**Jeanie Bourke - Re: Fwd: 737 Congress St. storefront permit BP.2014-02785**

**From:** Jeanie Bourke  
**To:** Benjamin Wallace  
**Date:** 12/30/2014 9:17 AM  
**Subject:** Re: Fwd: 737 Congress St. storefront permit BP.2014-02785  
**CC:** Craig Messinger; David Petruccelli

137 CONGRESS ST. PORTLAND, MAINE
 ELEVATION: REVISED STOREFRONT
 1/4" = 1'-0"
 PROPOSAL: 9/4/13

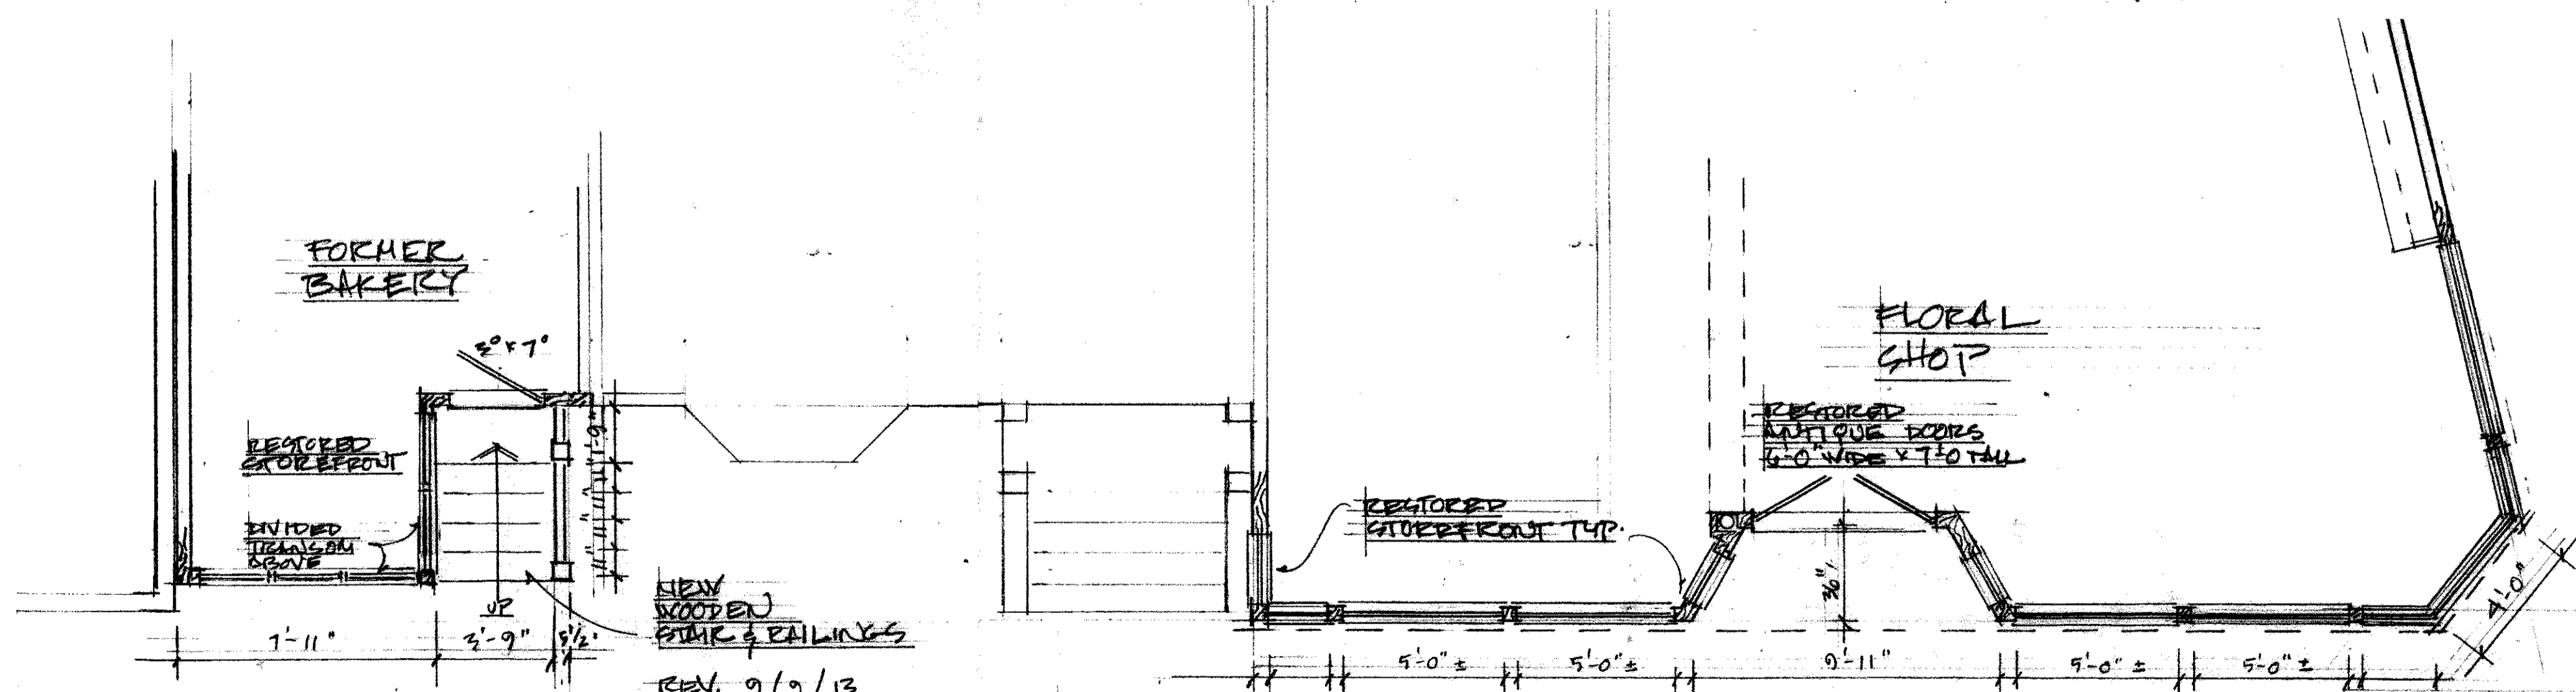
This appears evident when comparing the proposed elevation with the existing photo in Eplan. This permit is only for the storefront restoration and will not impact the interior layout and exit pathways.

Can you confirm this: that the egress access within the spaces that will be exiting through the two new exits are within required common path of travel? The applicant's provided no floor plans showing how the exit access is arranged and distances. She may be fine, but I have no way of knowing this.

There is no change to the first floor egress pattern for the other units in the building, because the stand-alone retail spaces do not exit or enter through the central hall. Jeannie Bourke has been involved with the most recent proposals and confirms there is no additional requirement based on retail customer occupancy well below

50 persons, and antique door restoration may be allowed. Neither space communicates with the rest of the property, and the former bakery has only been used for basement access for storage.
